Thank you for your comments issued by email on 24th May in relation to our planning application (reference: 2613/APP/2024/1217) at Graze, Springfield Road. CBRE partially responded to these comments on the 3rd of June by email.

This letter full addresses the points raised in both your initial email from 24th May, inclusive of our partial response and the points raised by the Environmental Health Officer, to provide a full comprehensive response.

Address:	Graze Natural
	Springfield Road
	Hayes
	UB4 0TP
Drawing:	Proposed Elevations
Date:	24/04/2024
Scale:	1:100@A3
Drawn:	SA
Checked:	PF
Dwg. No.	564791-E-00
	Rev. B

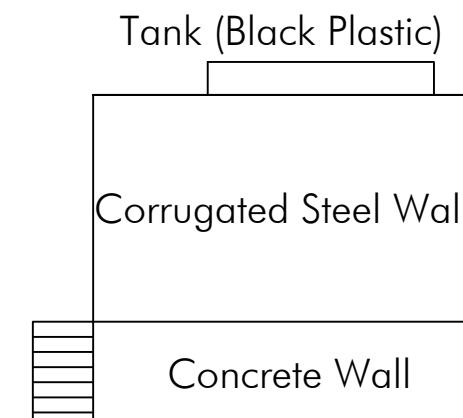
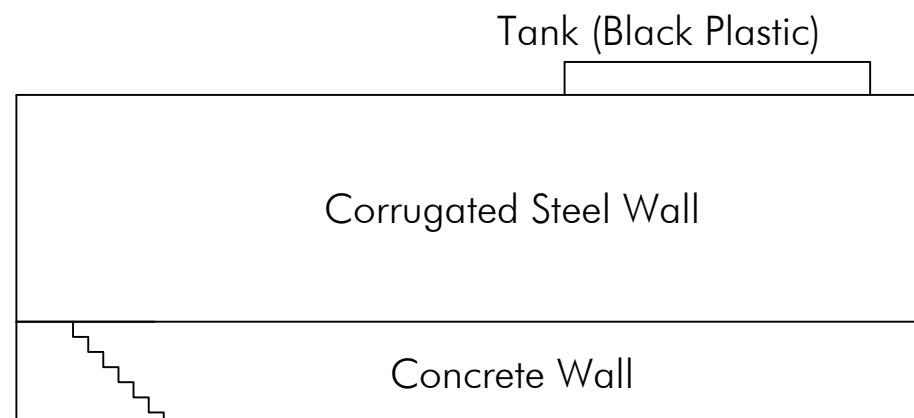
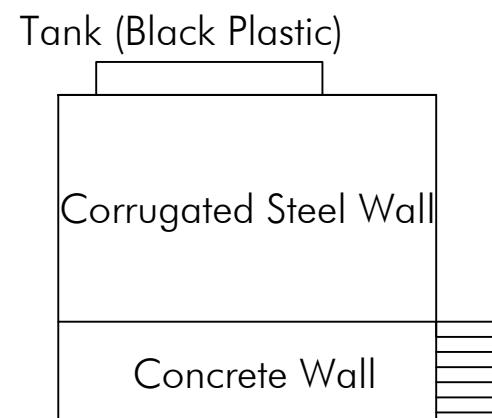
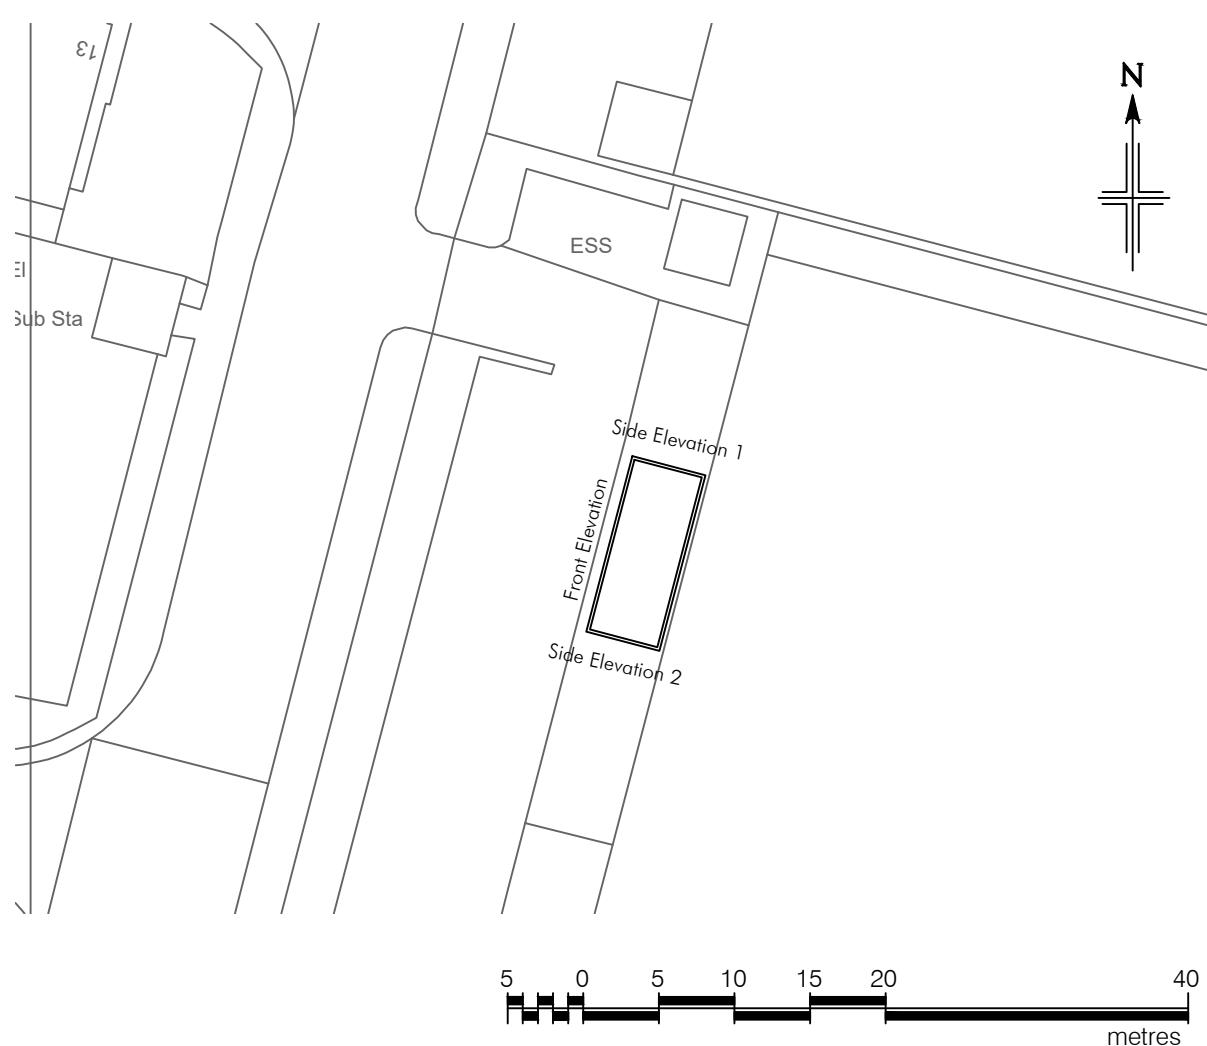
Although as you note is utilitarian in its design, we consider the development to be appropriate for its location set within the existing established industrial estate. It is also entirely functional, to ensure that the plant required to appropriately treat effluent is appropriately screened for safety reasons.

The tank shall comprise black plastic, the plans have been updated to reflect this.
